McDowell Engineering, Inc.

August 3, 2013

**RE: Lot 12, Block 1, Unit 2, Chamisa Ridge Grading & Drainage Plan, 6216
Wild Onion Ave. NW (B10/D002B)**

We received your review comments dated July 3, 2013 and offer the following response with the enclosed revised Grading & Drainage Plan.

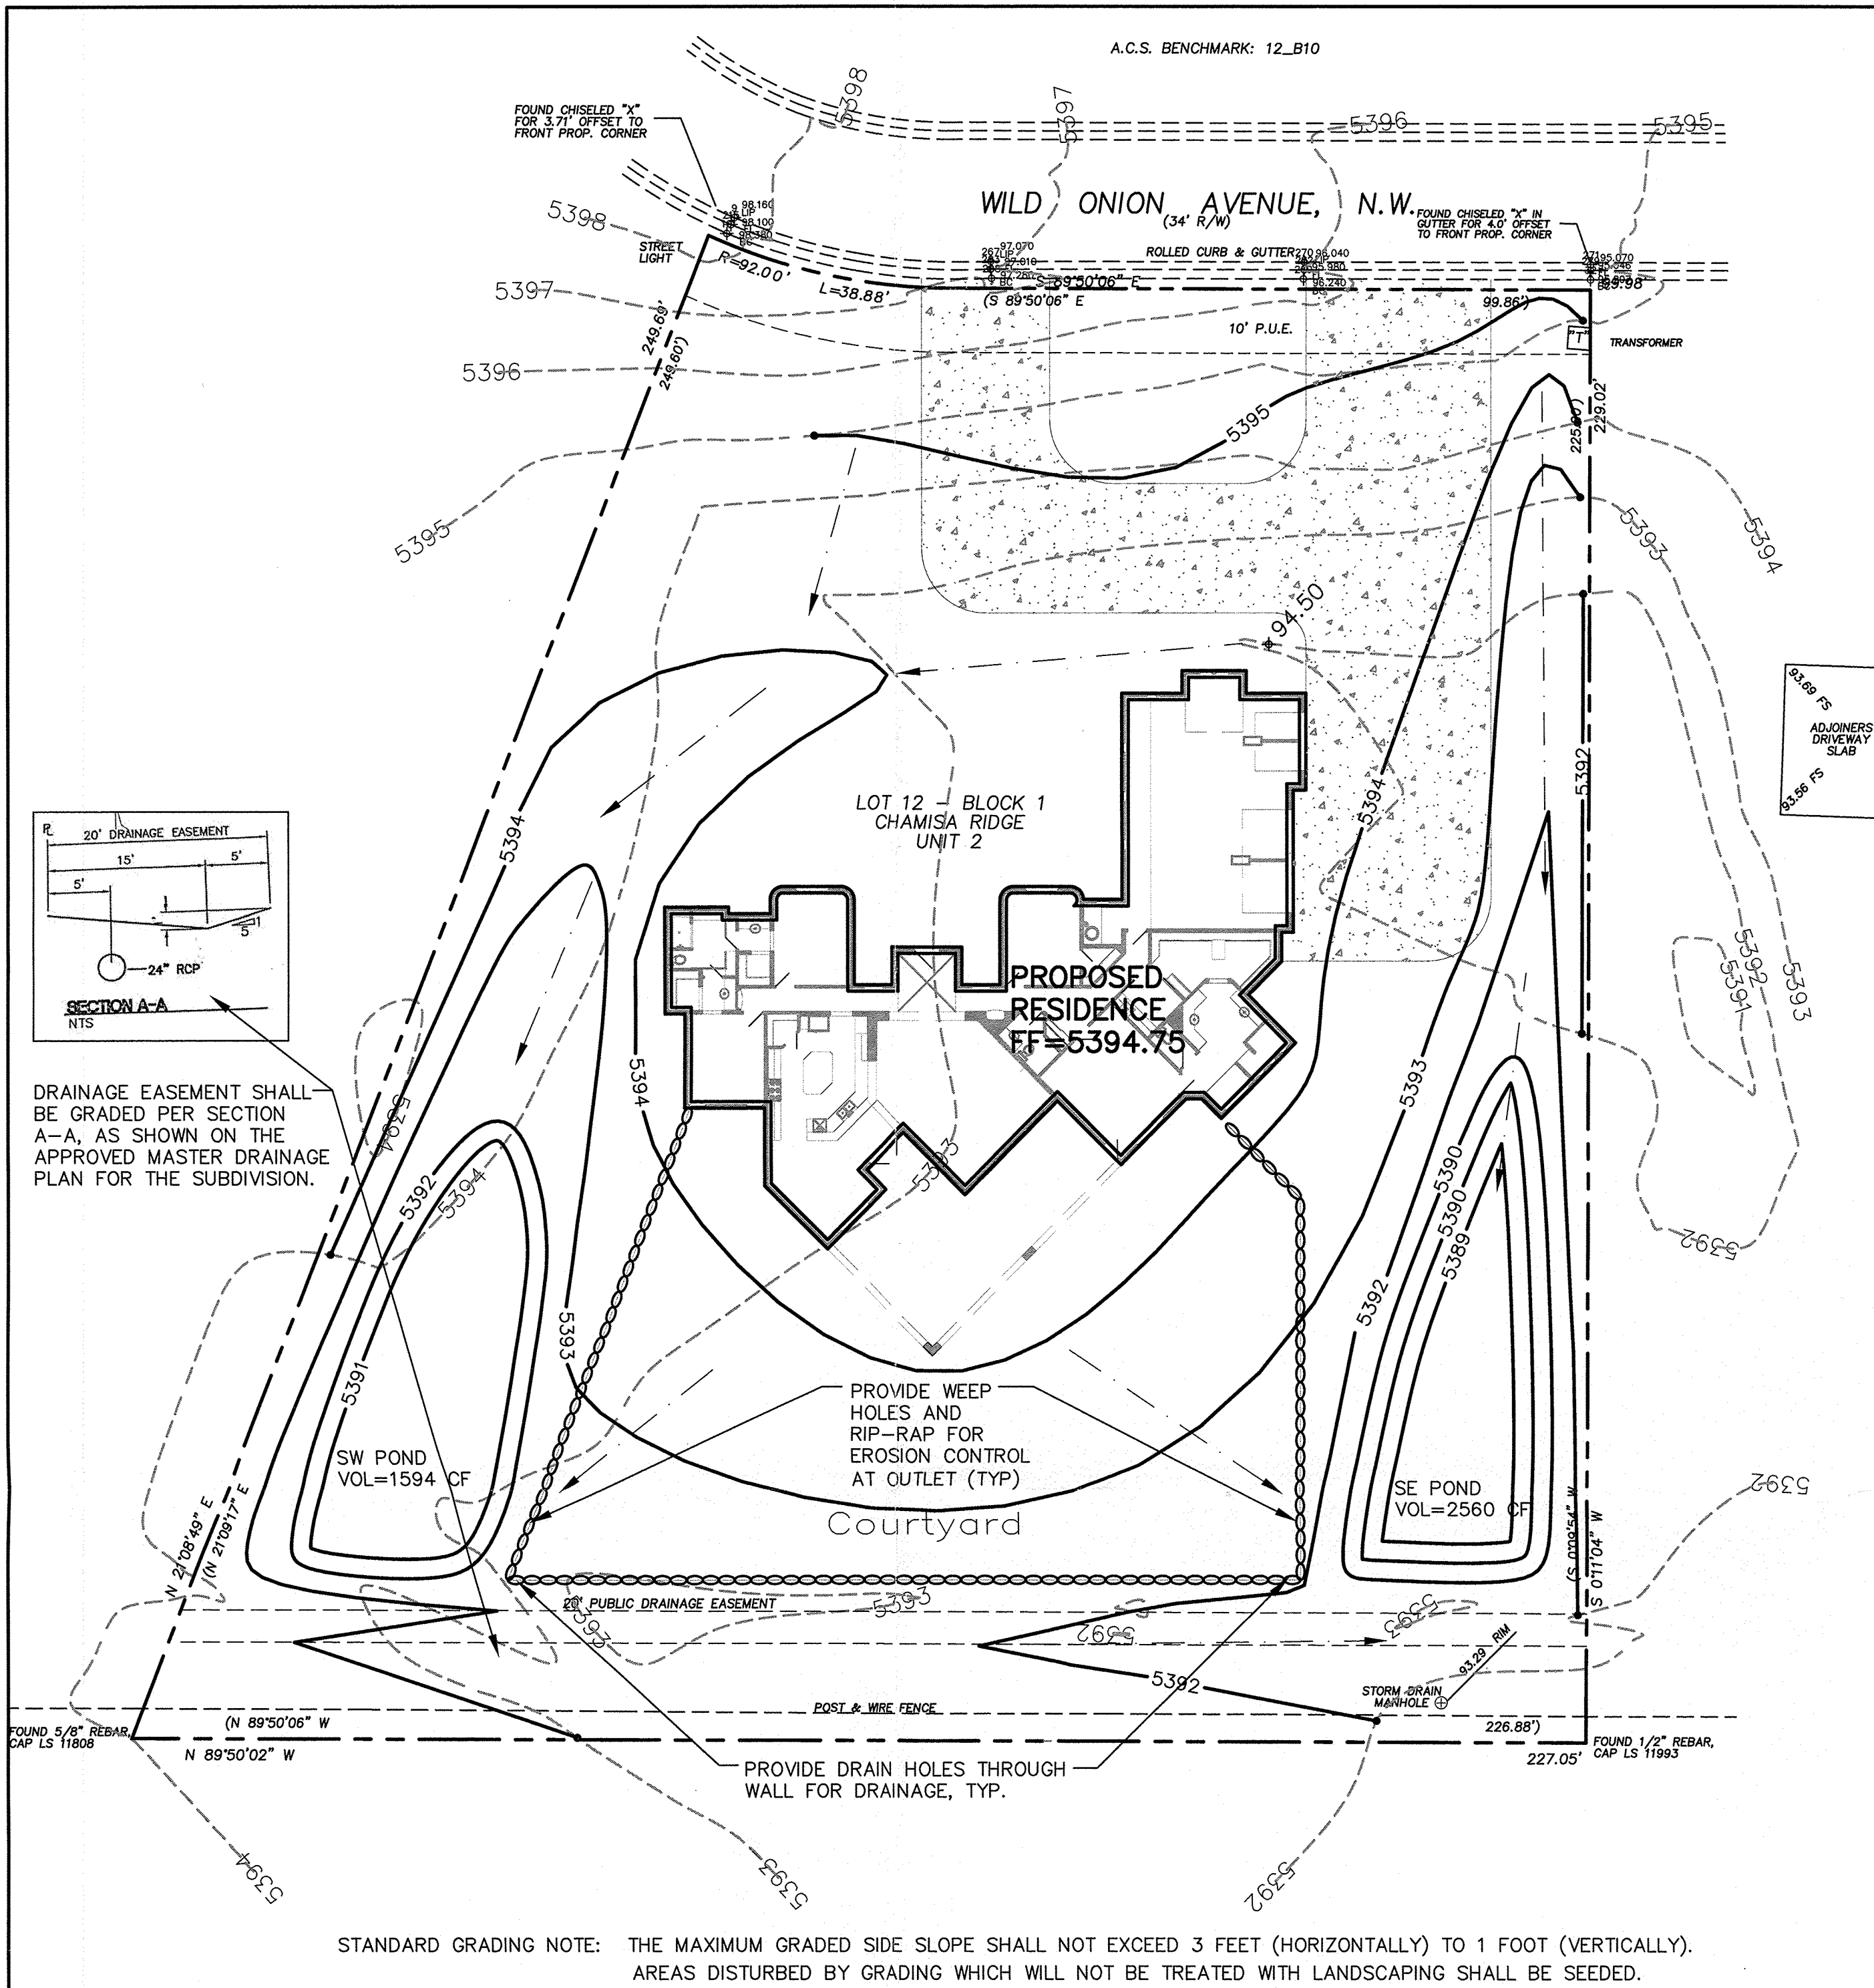
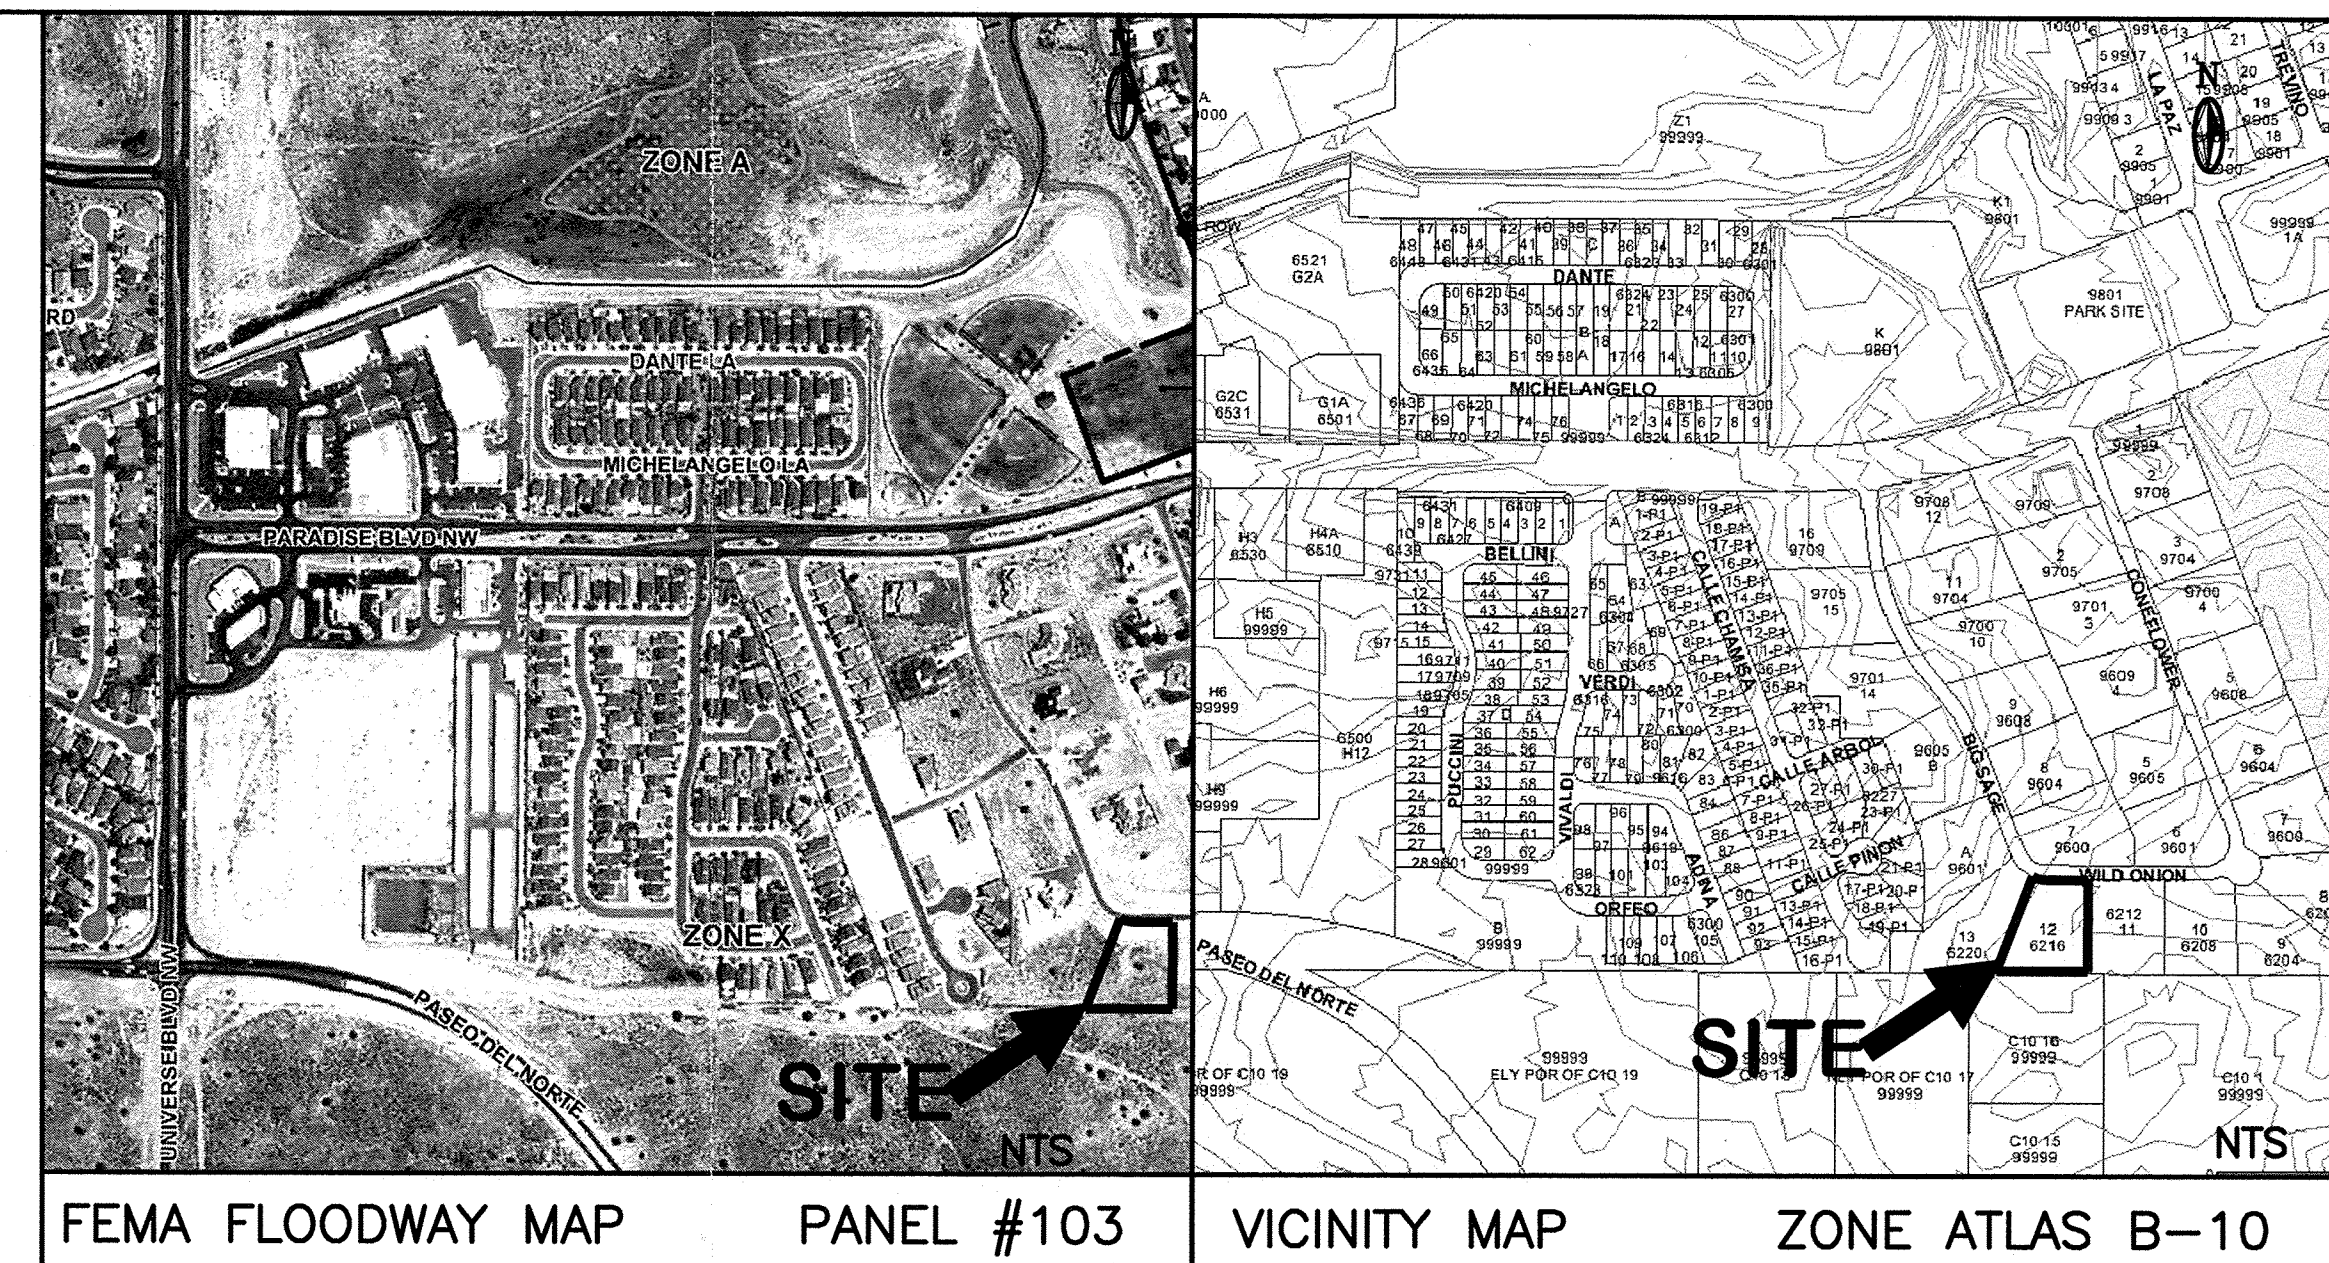
- We have modified the plan to allow for water harvesting ponds to hold the volume of water generated from a 100 year storm. At this time, the developed runoff cannot be fully conveyed downstream to the detention pond through the existing drainage easement as several lots downstream have not been graded to allow for this conveyance per our discussion on August 2, 2013.
- Top of curb and flowline elevations have been added to Wild Onion Ave. to show that an adequate water block exists.
- All proposed contours have labeled and the font has been enlarged on the existing contours to be more legible.
